BRADLEY POINT FILING NO. 1

CONSTRUCTION PLANS

BRADLEY POINT FILING NO. 1		COVER SHEET	
PROJECT NO. 70-074	SCALE: HORIZONTAL: N/A VERTICAL: N/A	DATE: 08/31/2023	SHEET 1 OF 8 CD01
DESIGNED BY: DM	DRAWN BY: CUP	CHECKED BY: DM

POND 2 SITE PLAN (PRIVATE)
 SCALE: 1"=10'

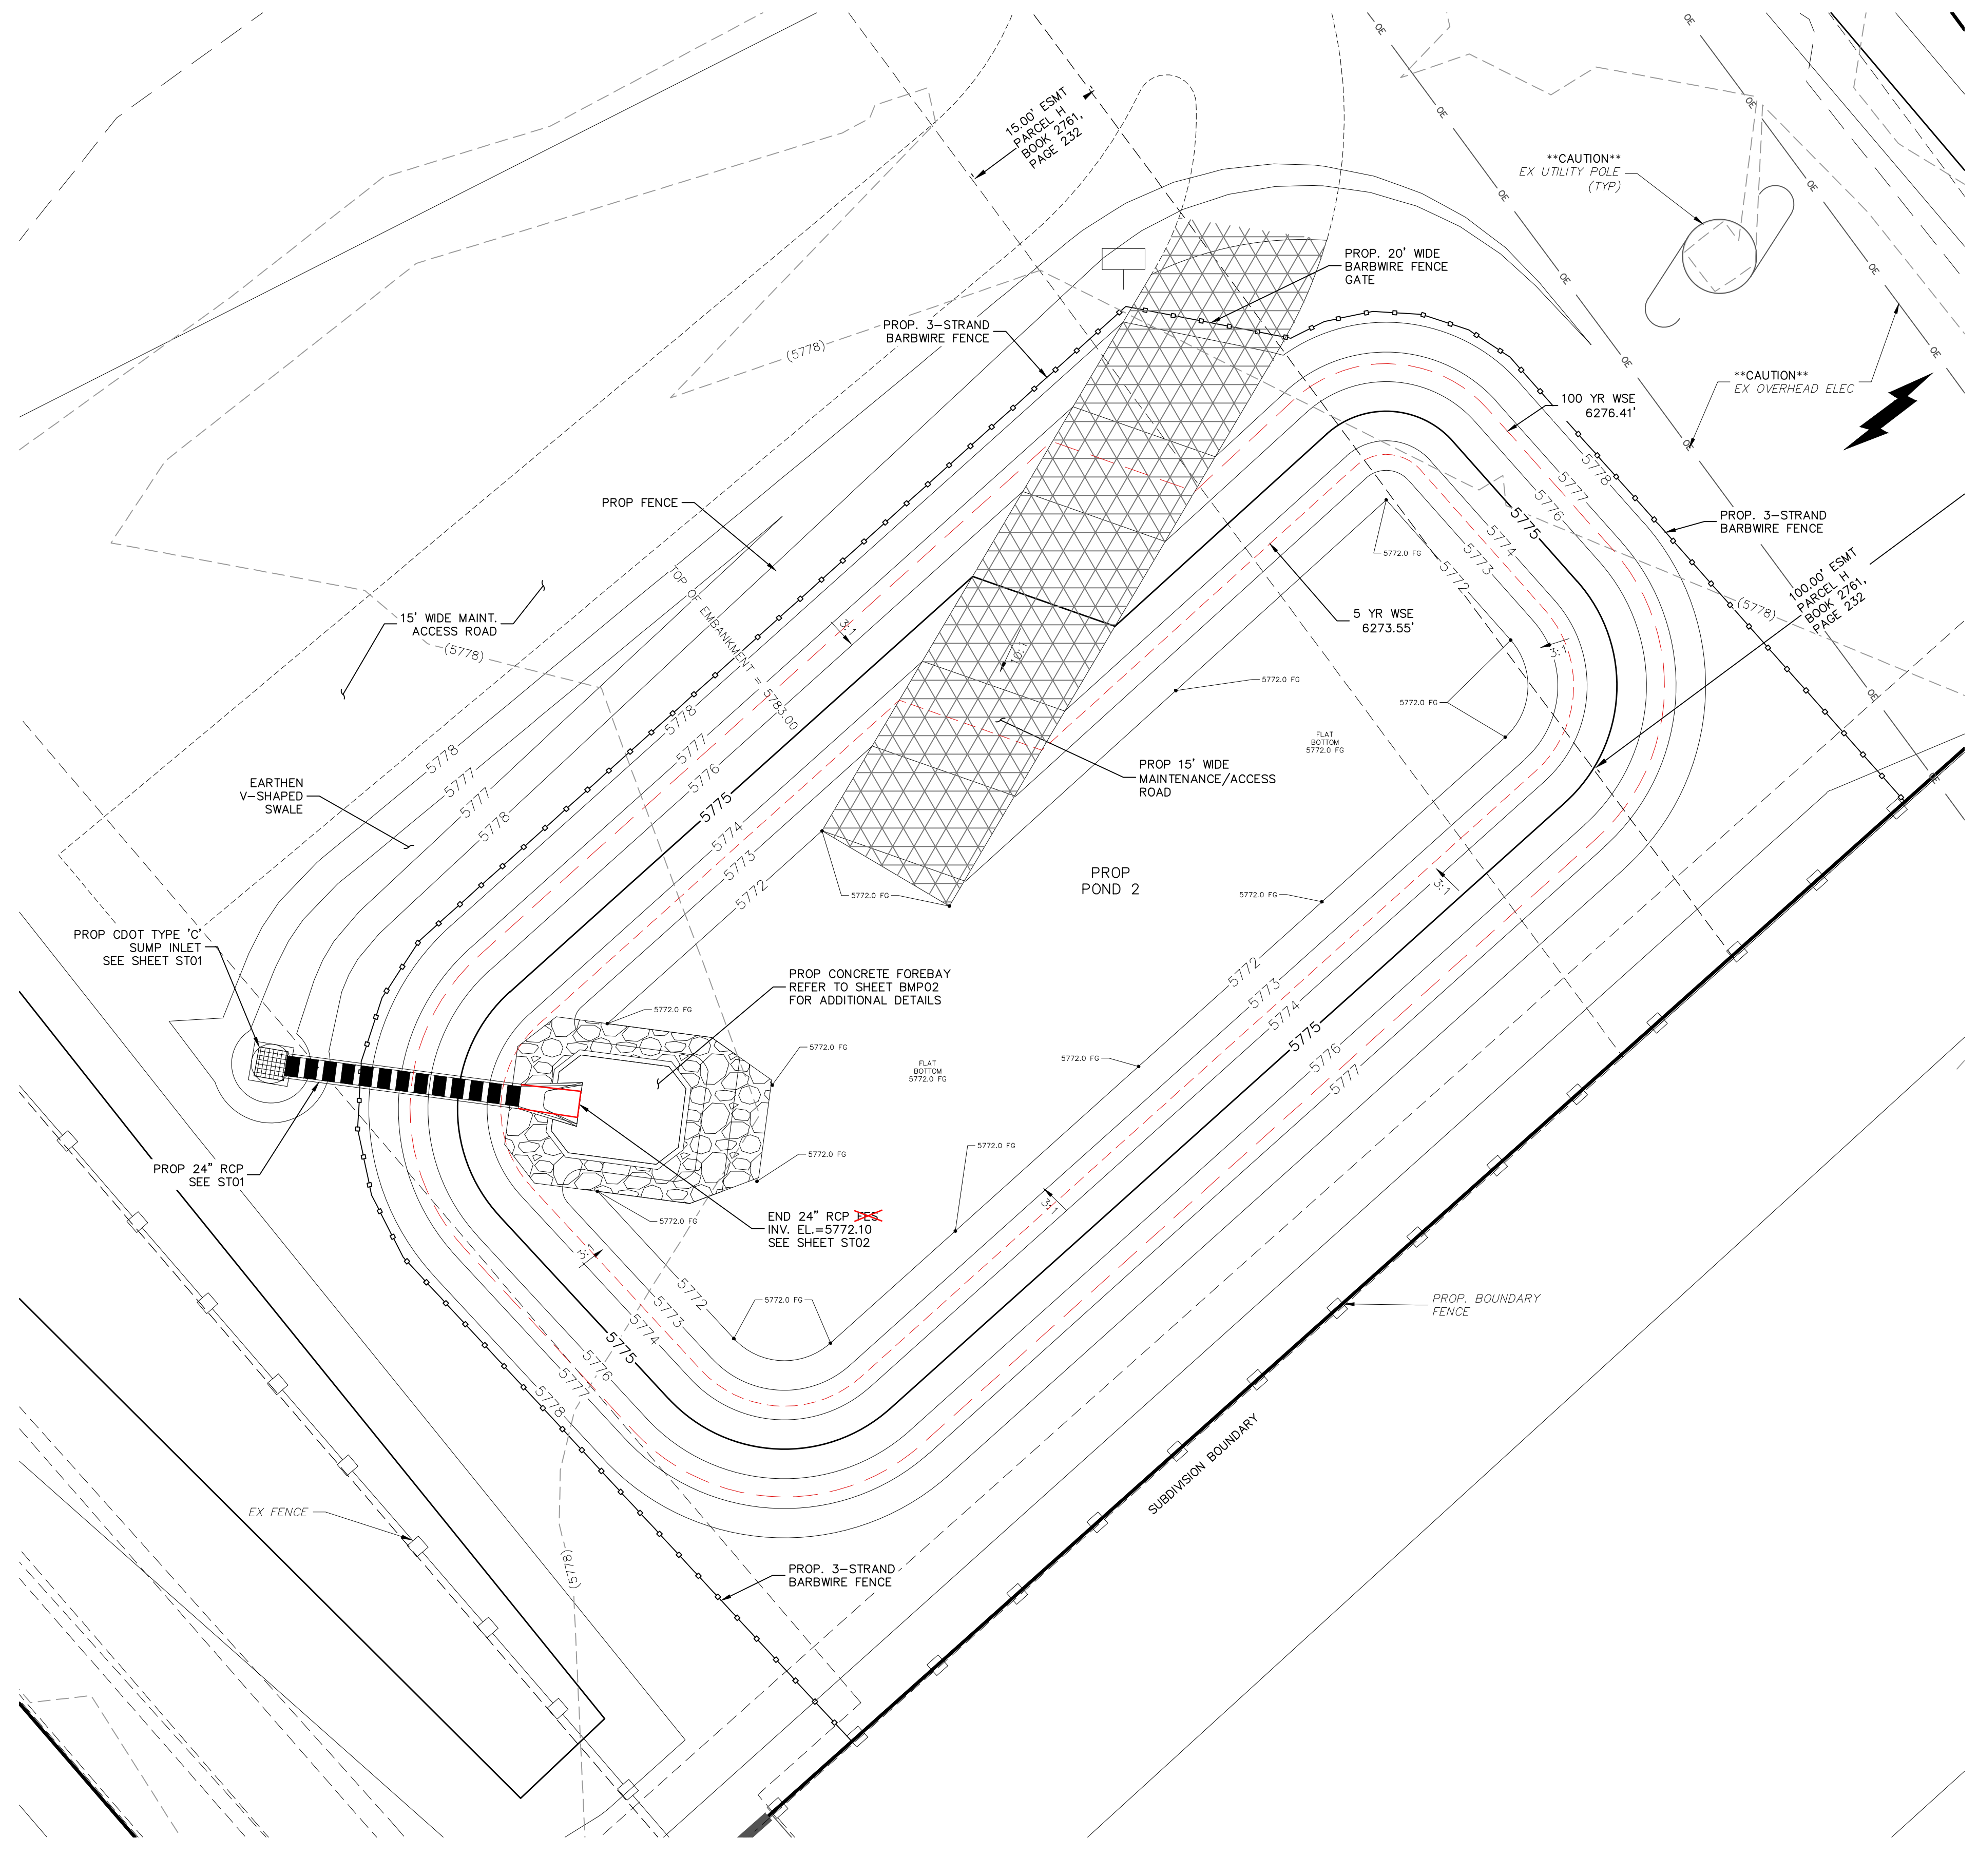
No FES was present in the field. Please callout this change.

POND 2 FOREBAY
 SCALE: 1"=2'

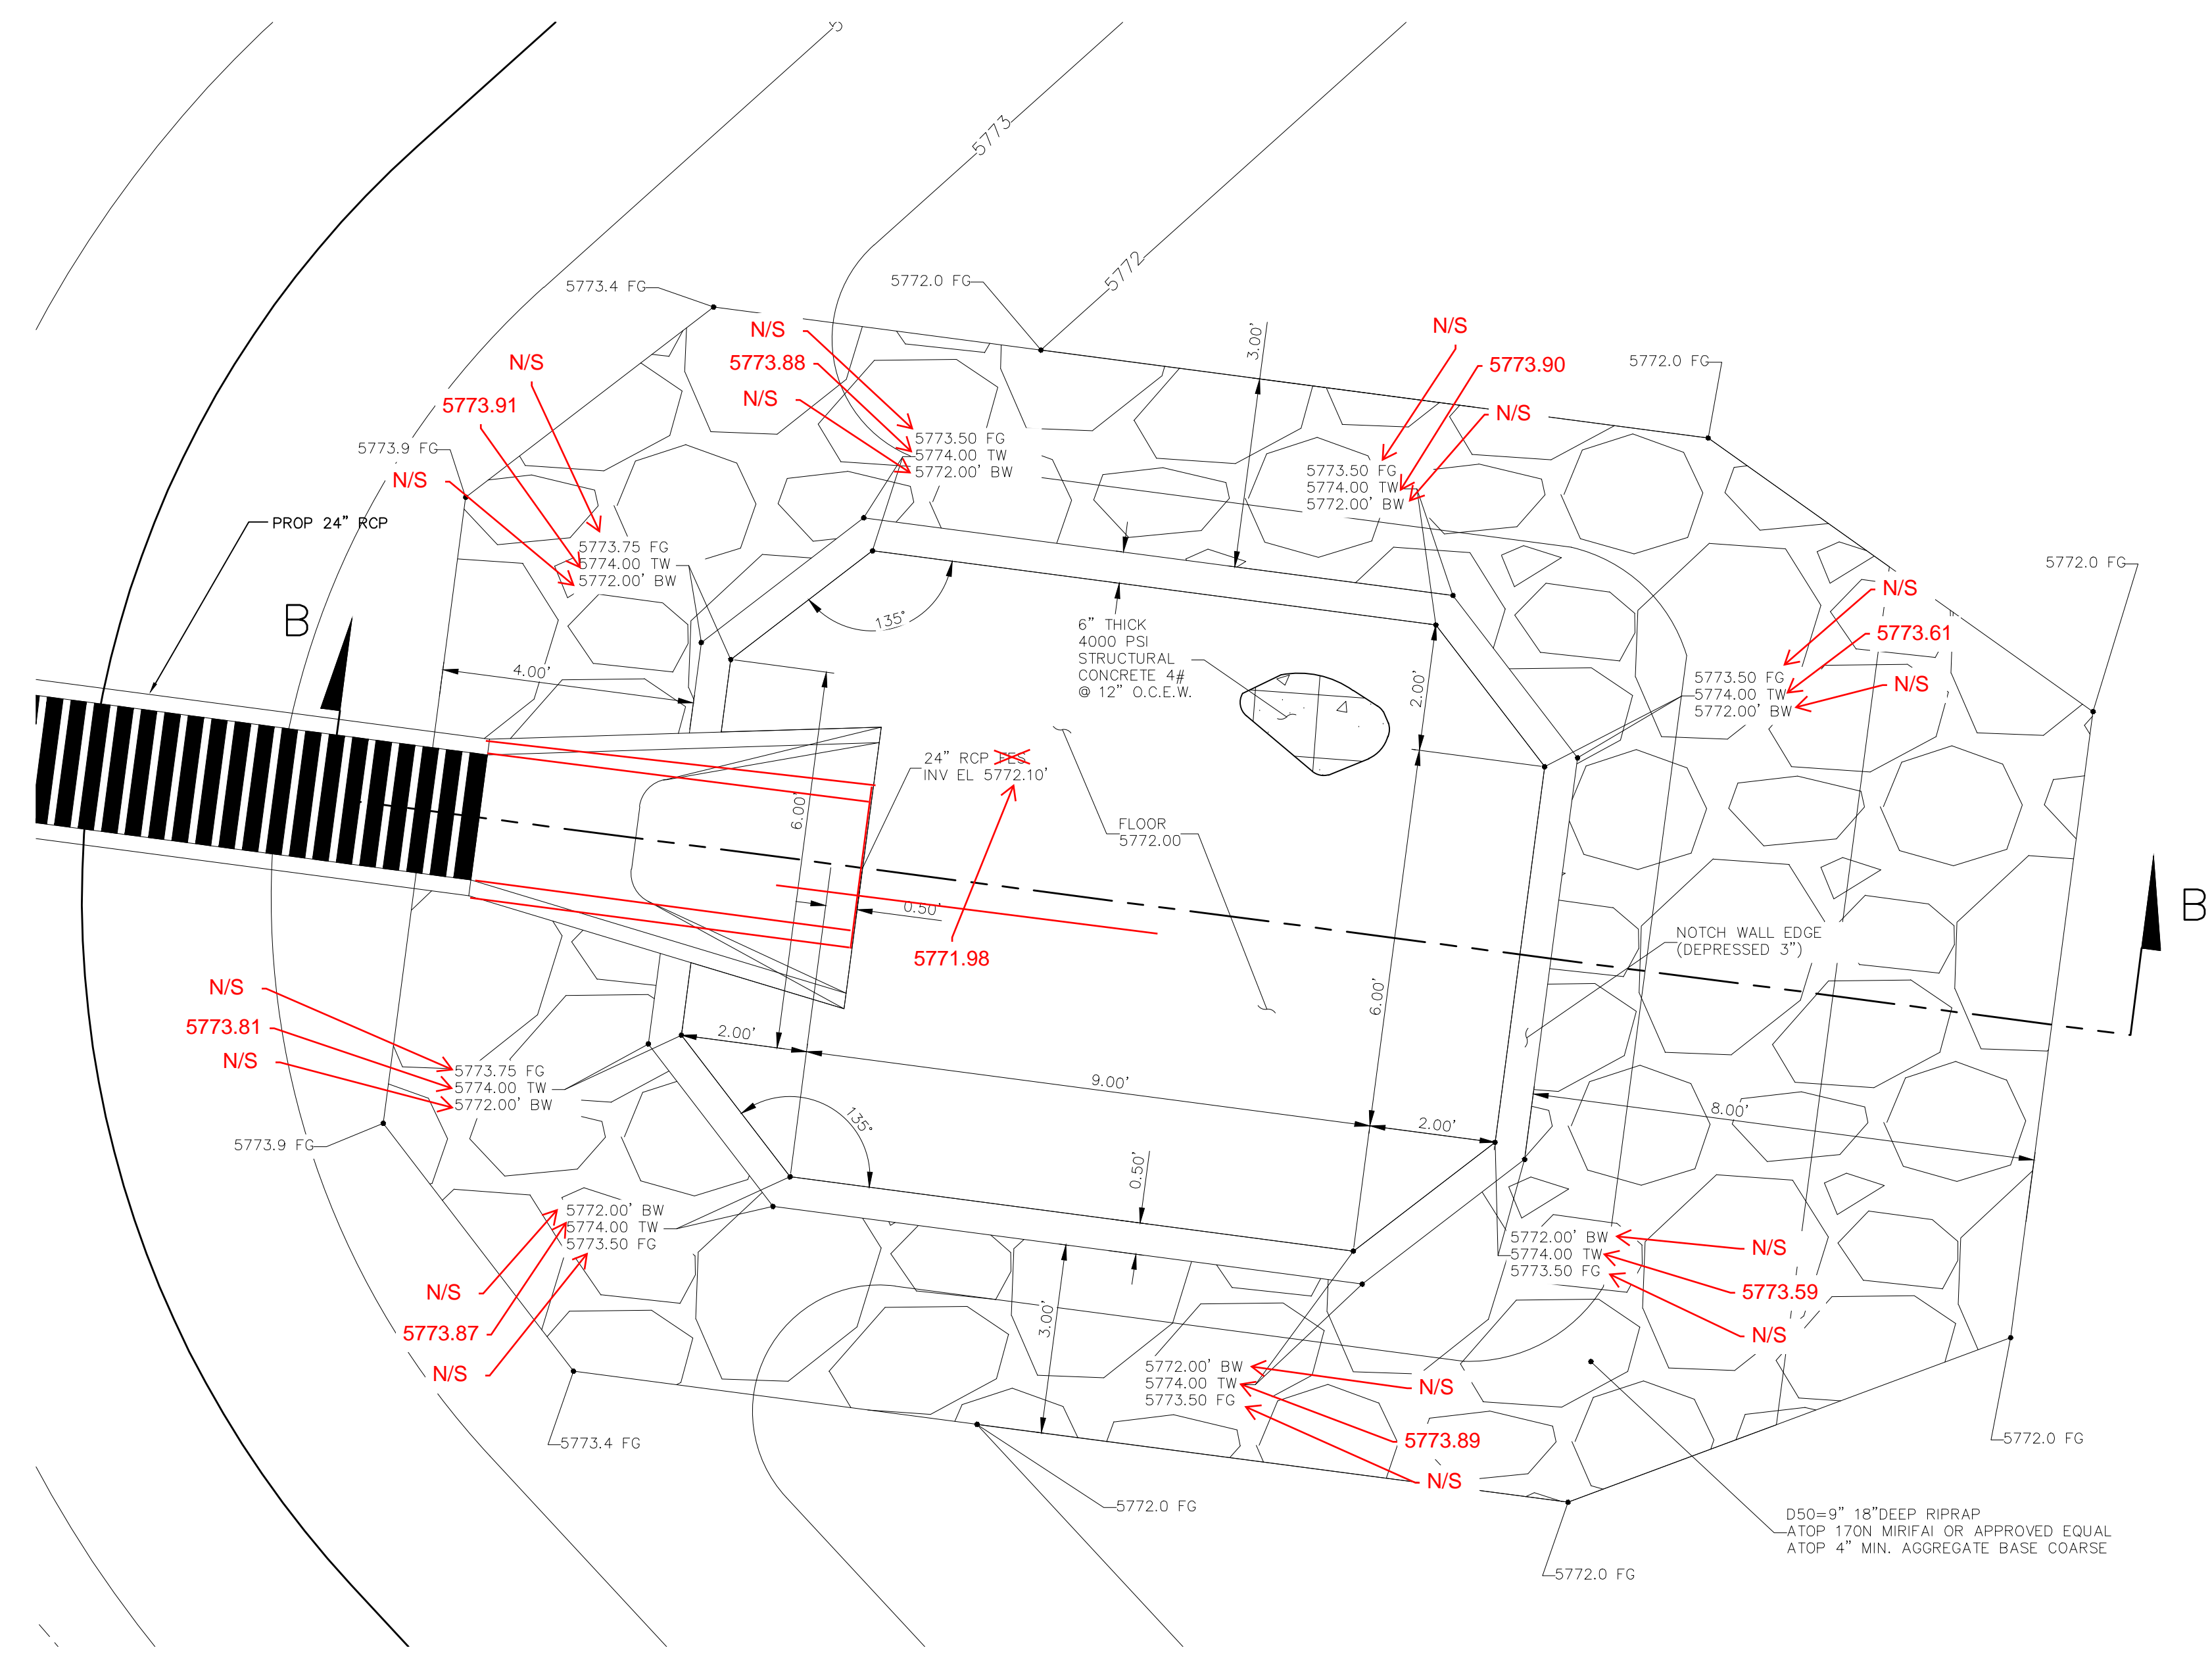
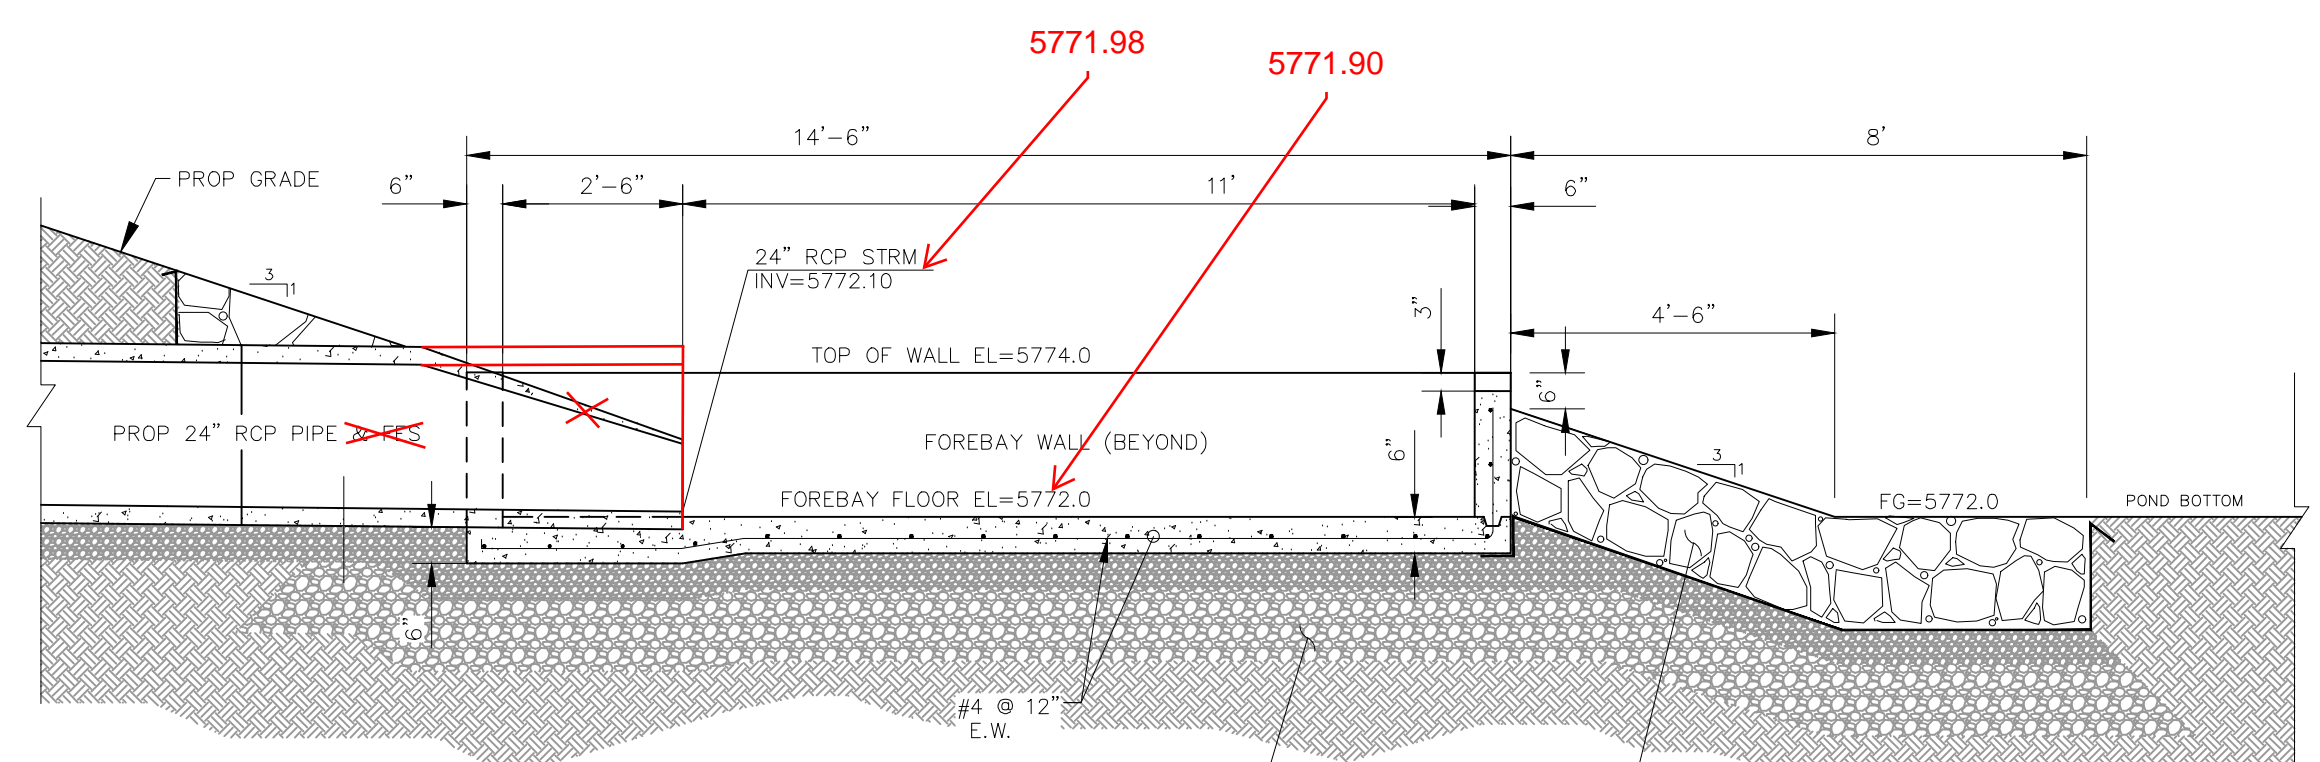
No FES was present in the field. Please callout this change.
